Application no: H16/1318/01

Description: Proposed extension to bungalow

Location: 12 Carlton Close
Spalding

Amendment: Garage reduced in length and repositioned
LCC letter dated 11 Jan 02 & Dwg.No.3056-2A

Drawing No. 3056~2A

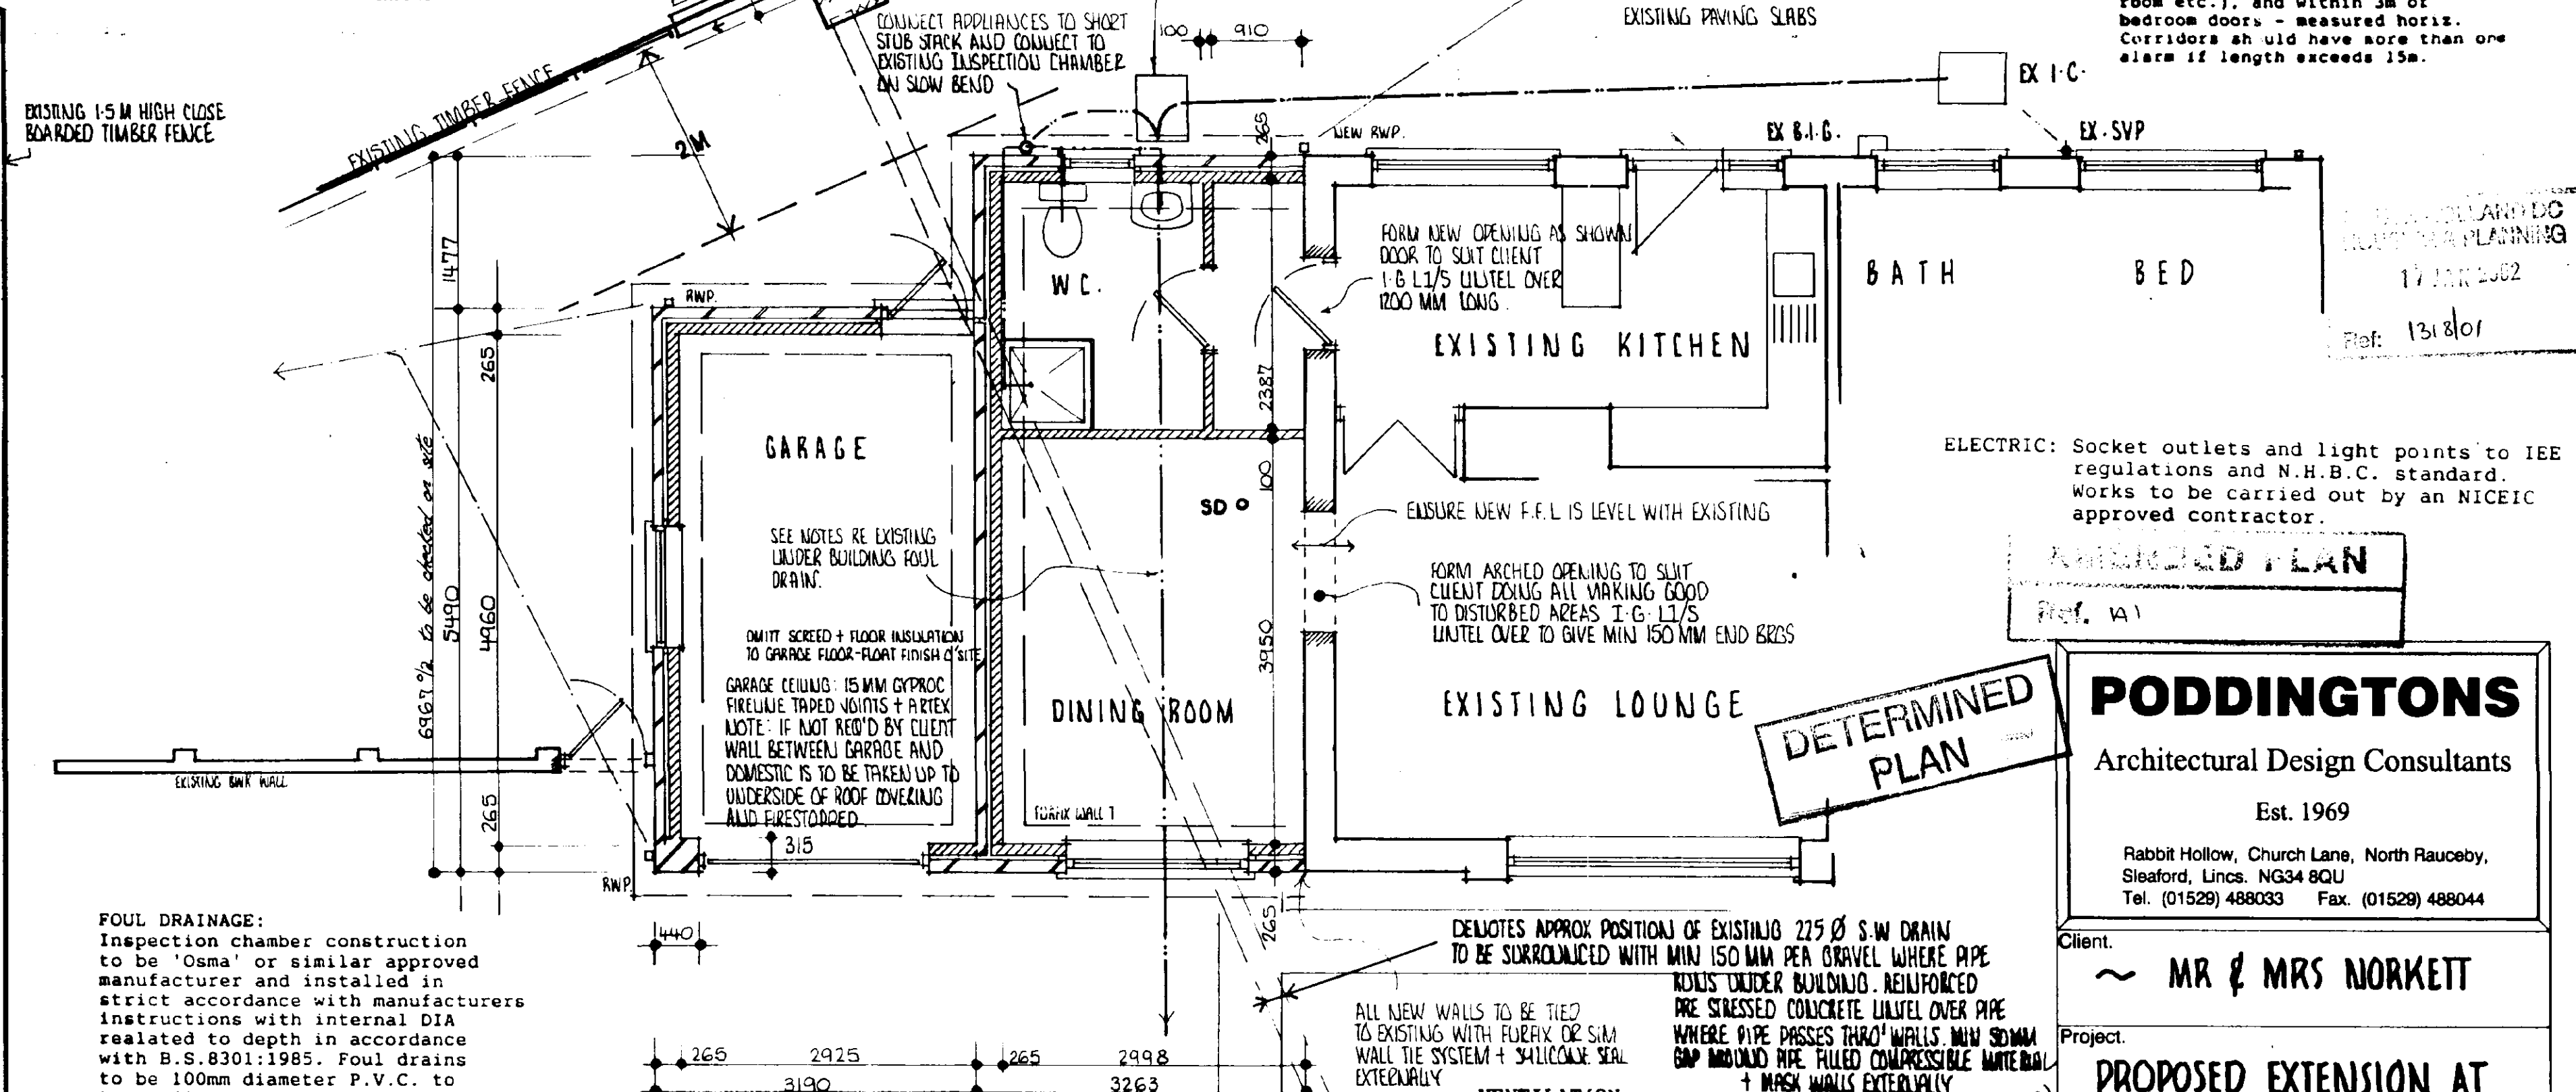
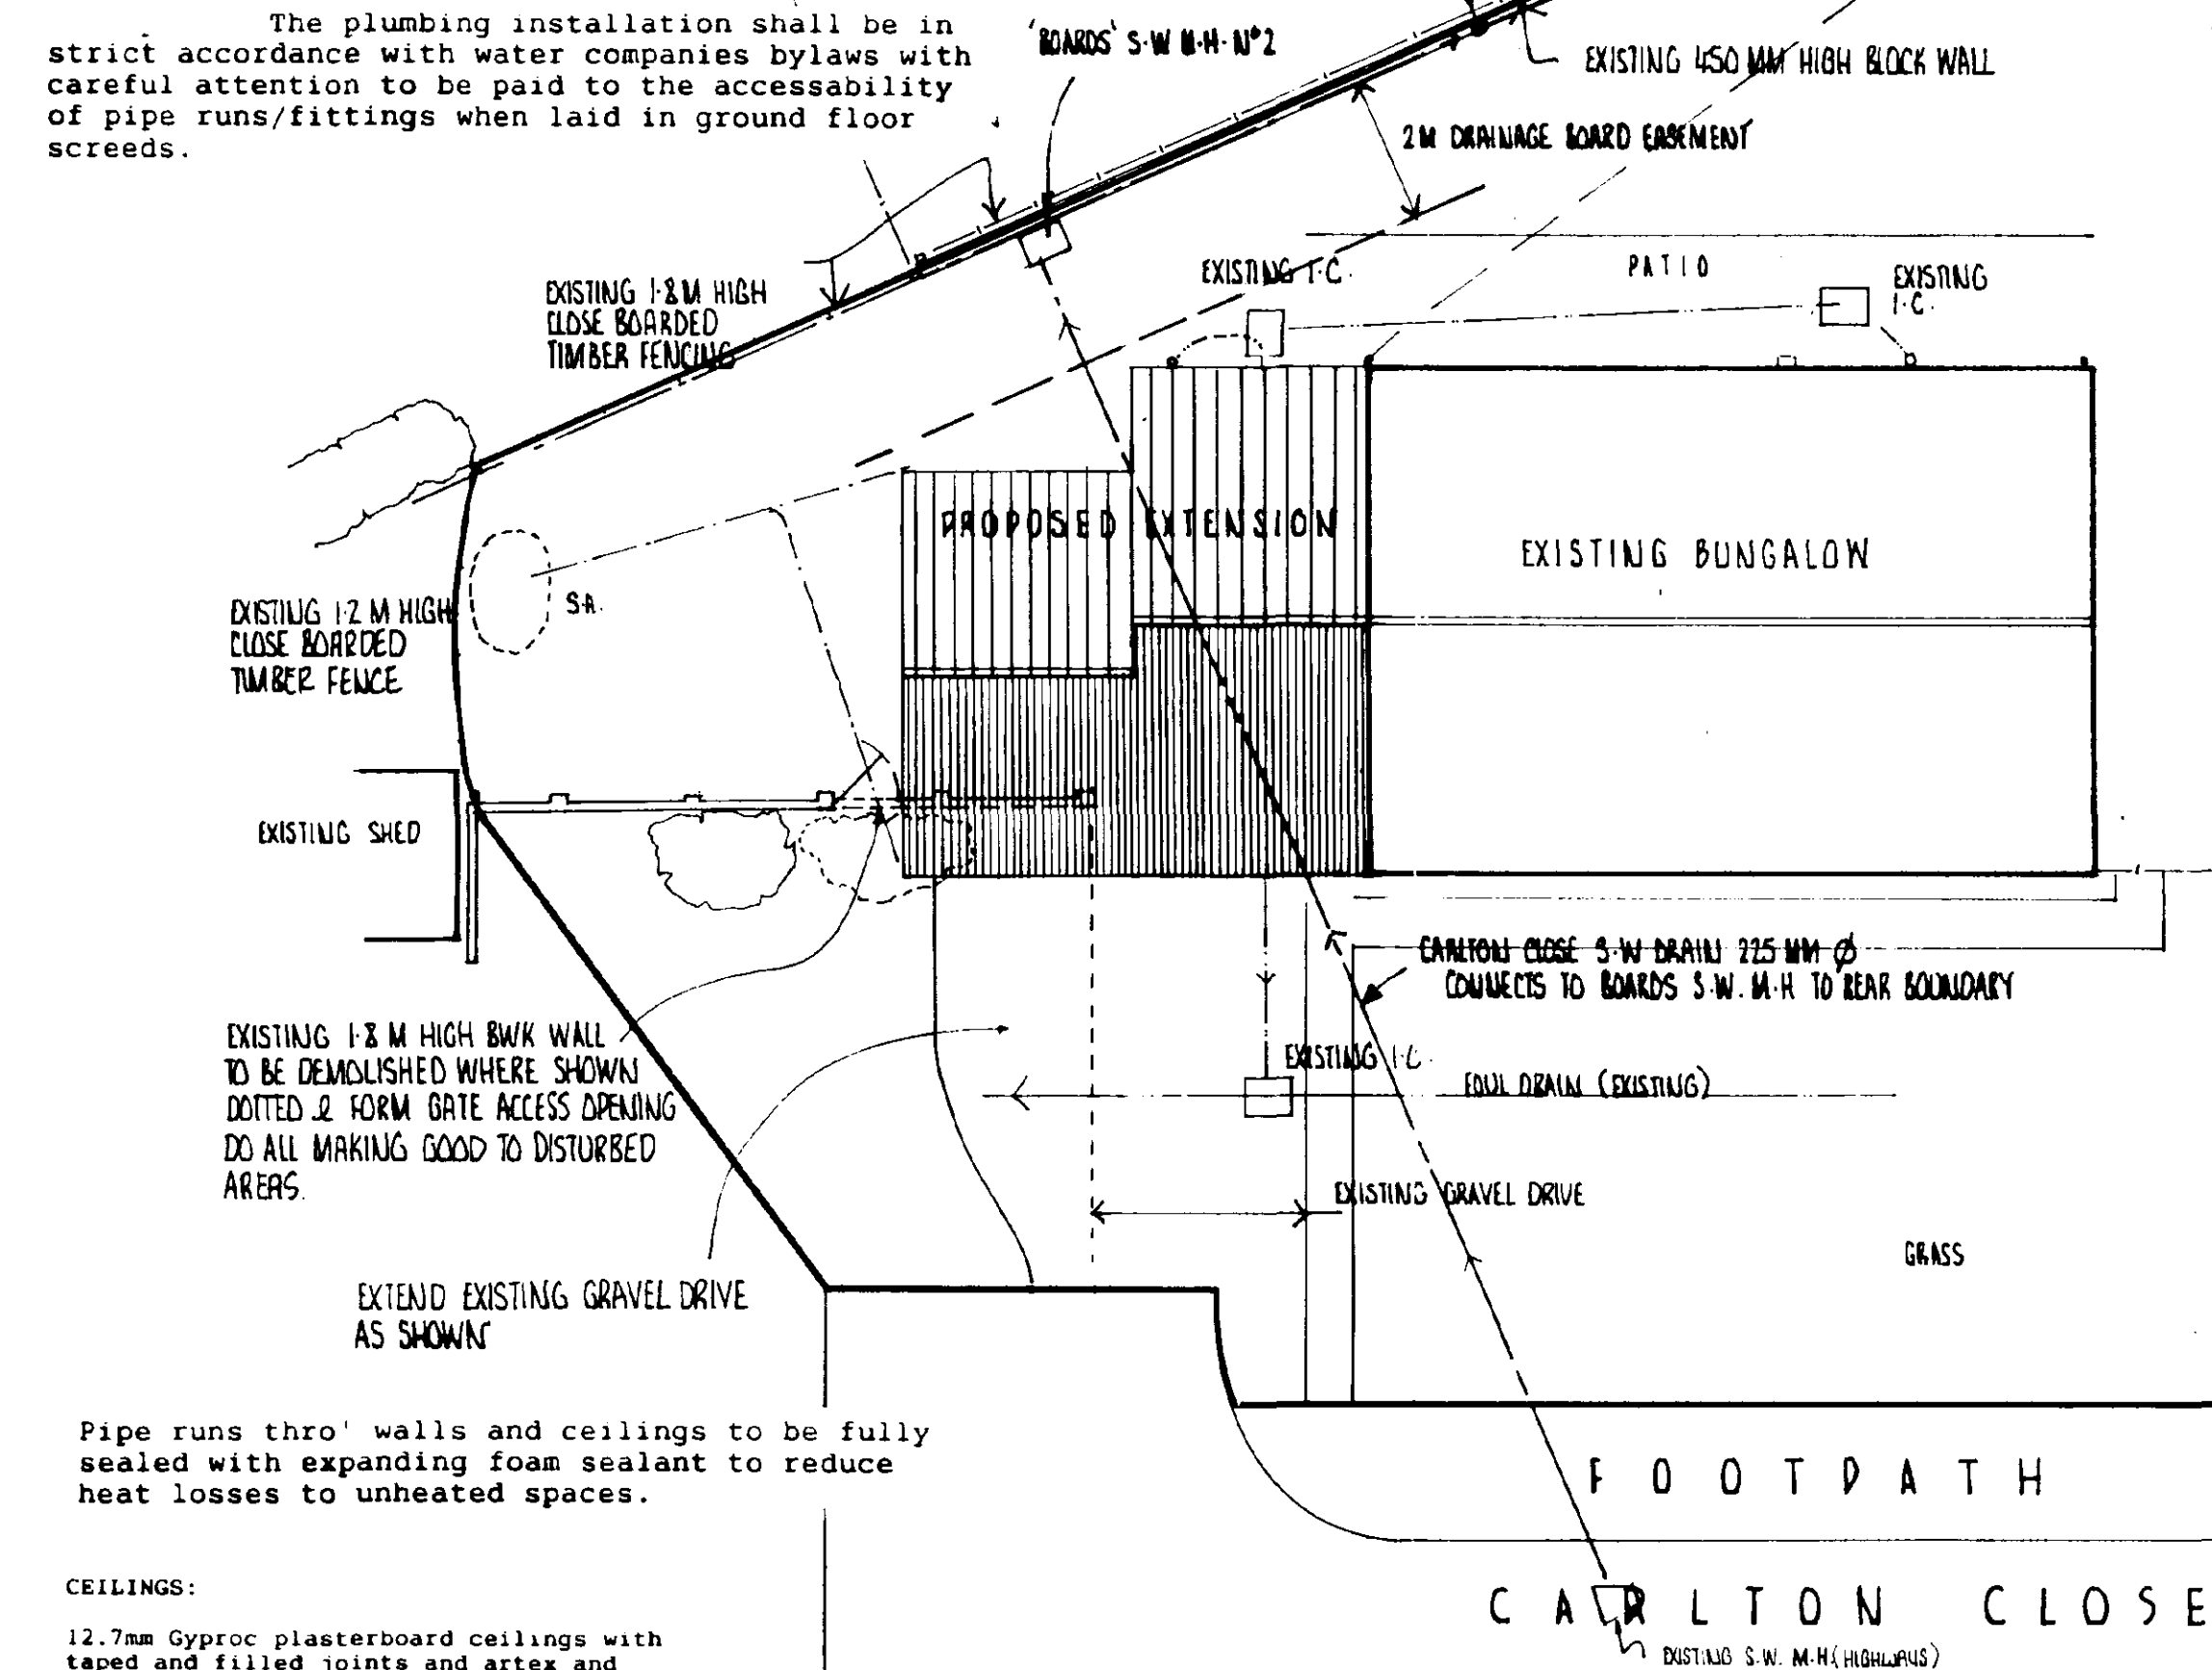
ATTACHED GARAGE REDUCED IN
LENGTH AND REPOSITIONED DUE
TO PROXIMITY OF PIPED I.D.B.'S
DYKE TO THE REAR OF THE
EXISTING BUNKALOW :- A PLAN HAS
BEEN SENT TO LOCAL DRAINAGE
BOARD FOR FORMAL RESPONSE
